RE: Central Coast Council advice, State Significant Development (SSD-9813), 36-48 Donnison Street, Gosford.

I refer to your request for additional information, dated 26 May 2020, in relation to the above mentioned SSD application. We take this opportunity to provide a response to each of the items raised by DPIE, outlined in the table below.

**BUCHAN**

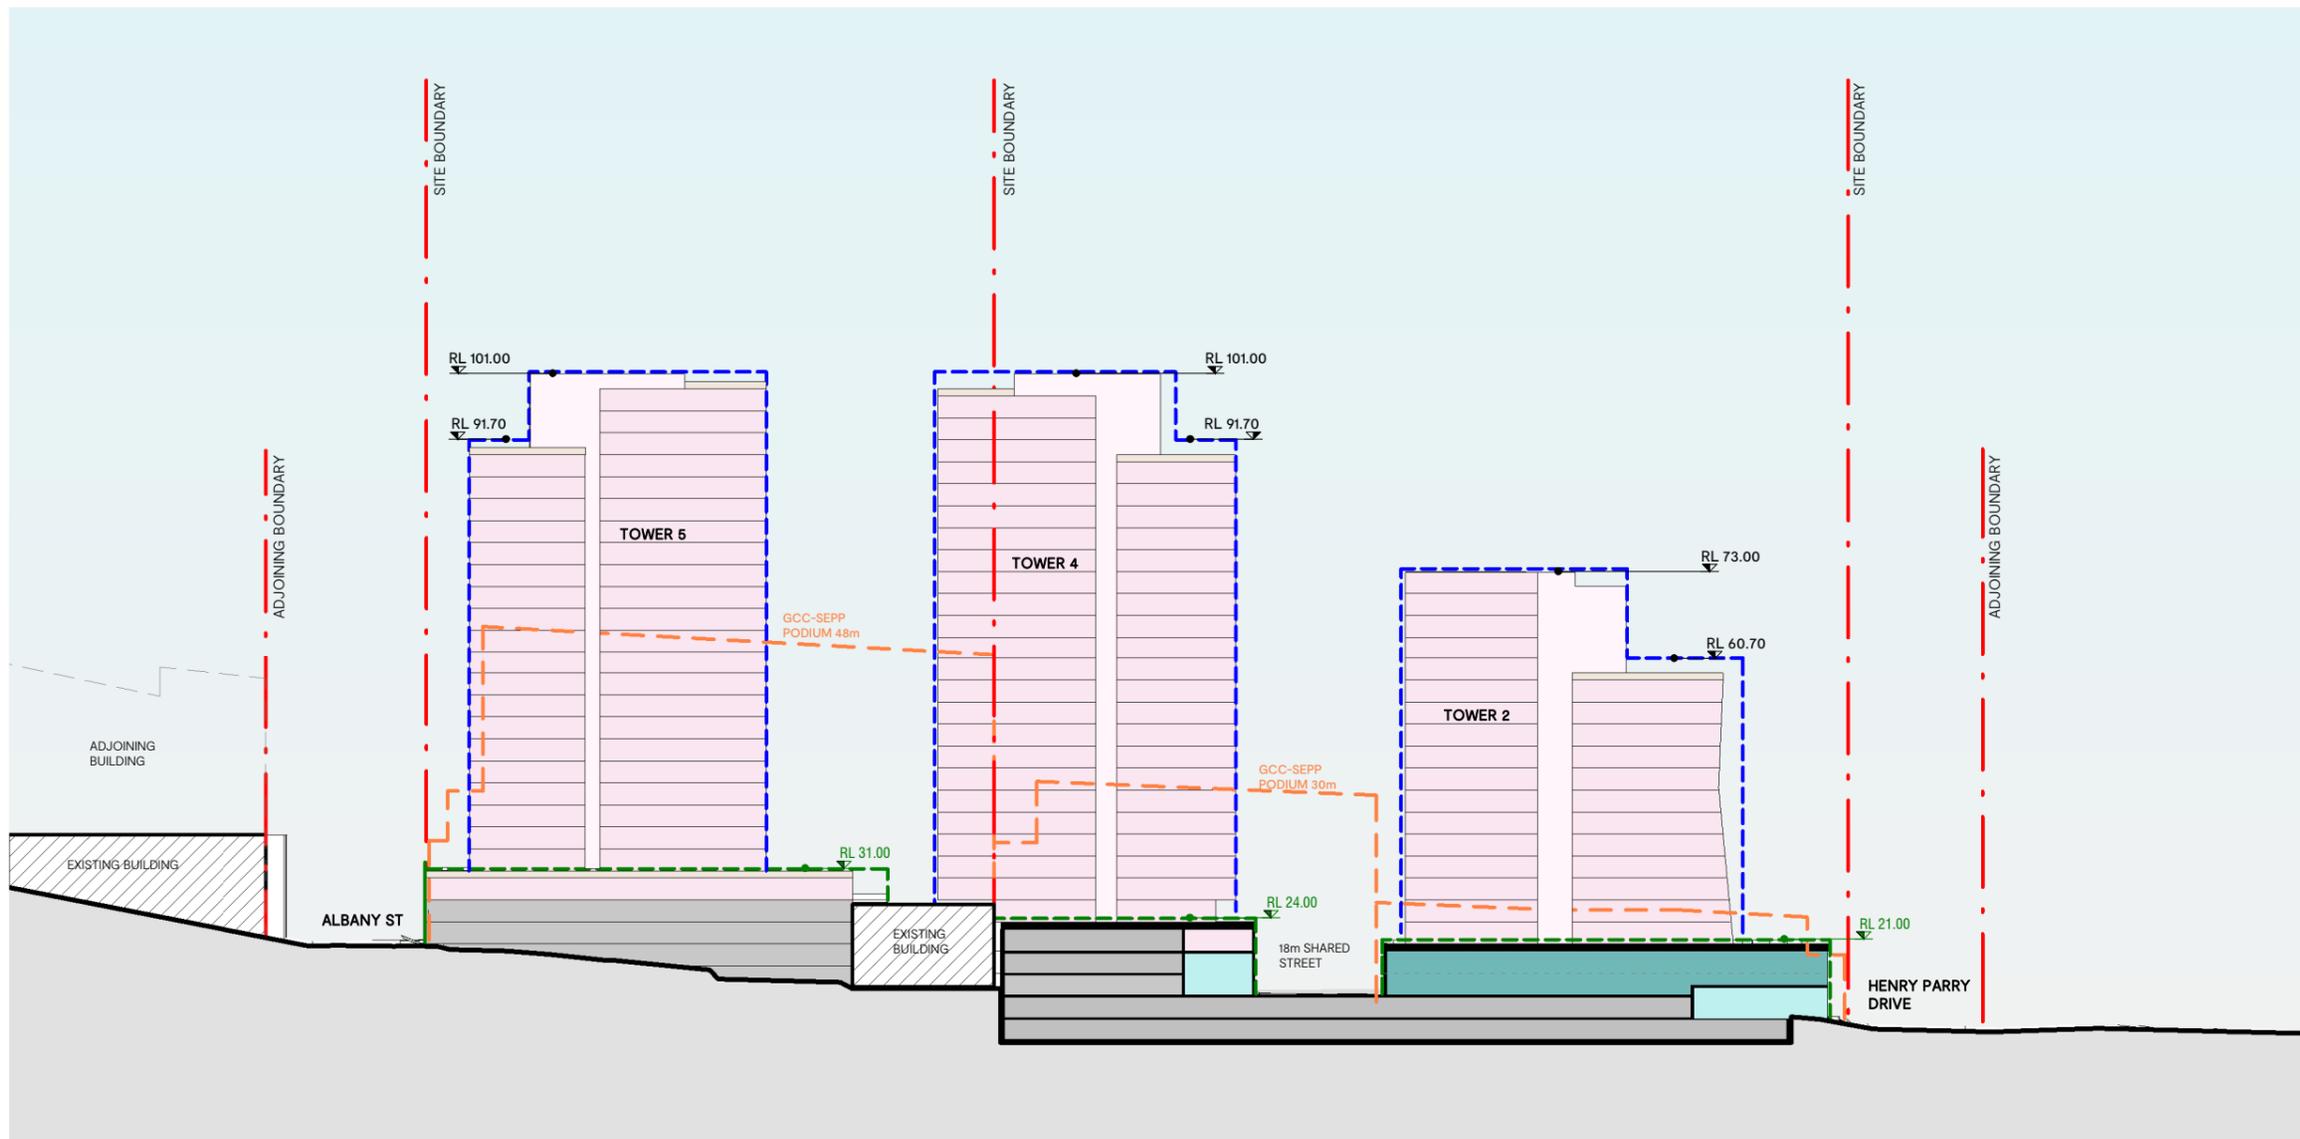
Please update elevations to show basements.	As above.
<p>Please provide an updated version of the block massing images ... to include current RtS envelopes:</p> <ul style="list-style-type: none"> • Page 25 to show the RtS envelopes in context with other approved (108 Mann St and 50-70 Mann St) and potential (imperial Centre) towers. The field of view should be slightly wider to more clearly show the above envelopes. • Page 69 to show the RtS envelopes in context with immediate surroundings. 	These images are currently being updated and will form a part of the updated VIA, which will be submitted to DPIE by 12 June 2020 at the latest.
Update the photomontage provided at page 12 of the VIA to include the massing of the development (in green). Also review the heights of 50-70 Mann Street to ensure they accurately reflect the development consent heights.	The updated VIA will be submitted to DPIE by 12 June 2020 at the latest.

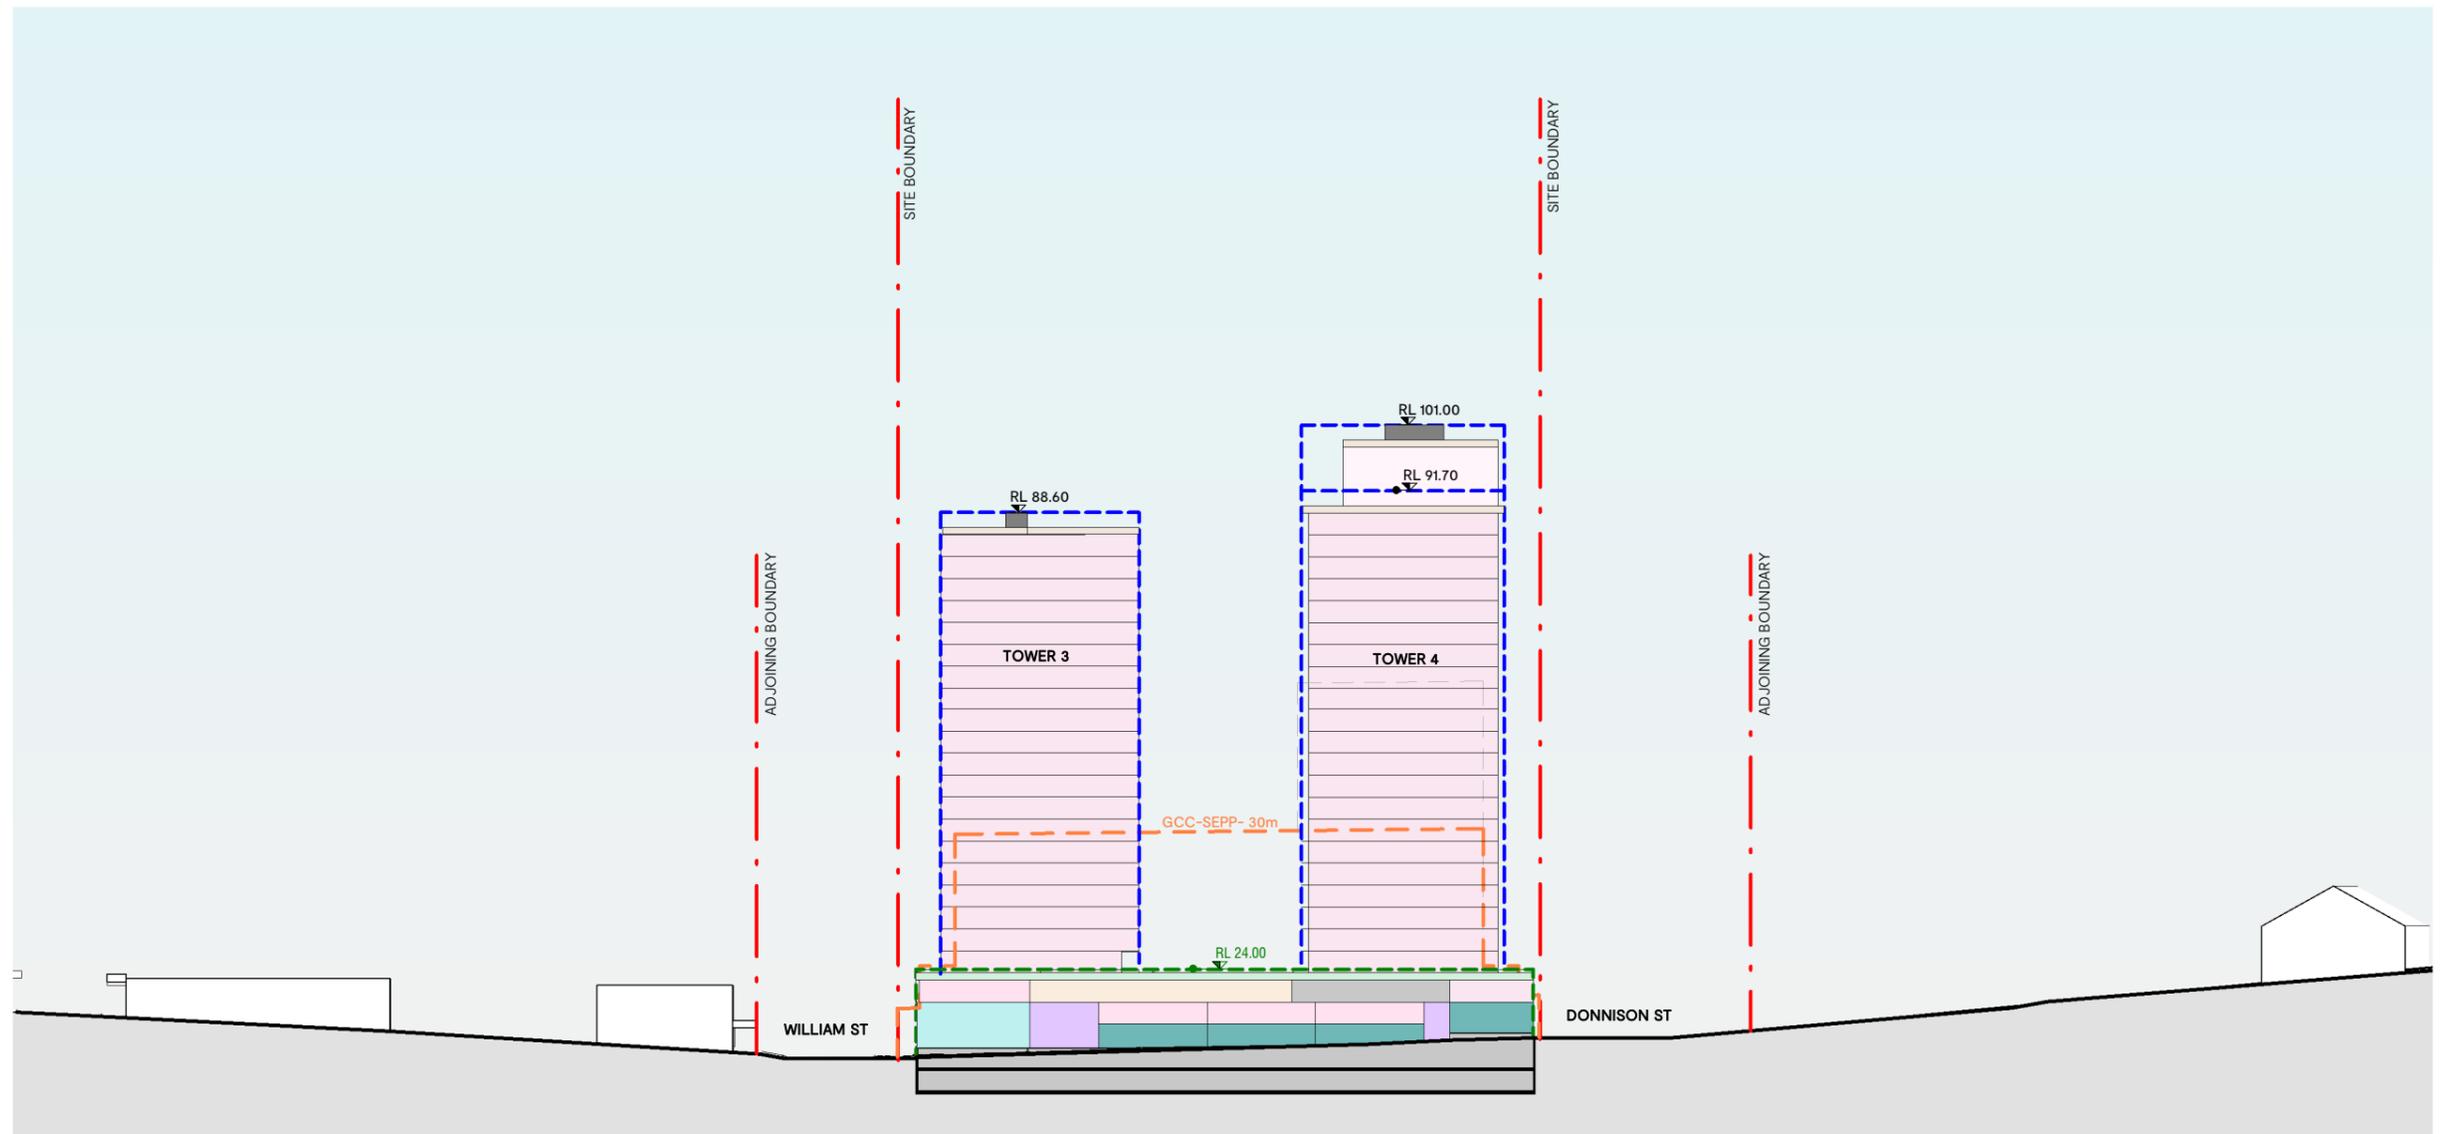
<p>The NIA appears to contain inaccuracies. Please review the report for accuracy and if required provide a revised NIA that identifies and assesses all sensitive receivers.</p>	<p>An updated Noise Impact Assessment is being finalised and will be submitted to DPIE by 12 June 2020 at the latest.</p>
<p>Drawings and images</p>	
<p>Please update drawing DA-02 as follows:</p> <ul style="list-style-type: none"> • Tower 1 annotated width appears incorrect (should it be 22m?); • Tower 2 annotated width should be a 'maximum' not 'minimum'; • Tower 3 should be provided with an annotated width; and • Separation distance between Tower 3 and 4 should be annotated. 	<p>DPIE's comments are noted with respect to annotations on drawing DA-02. Buchan have amended DA-02 to add or amend annotations as requested.</p>
<p>Please provide basement concept drawings indicating the location and extent of proposed basements.</p>	<p>Basement concept drawings have been provided and incorporated into the elevations and sections showing the extent of excavation required for basement parking, and including a minimum RL.</p>
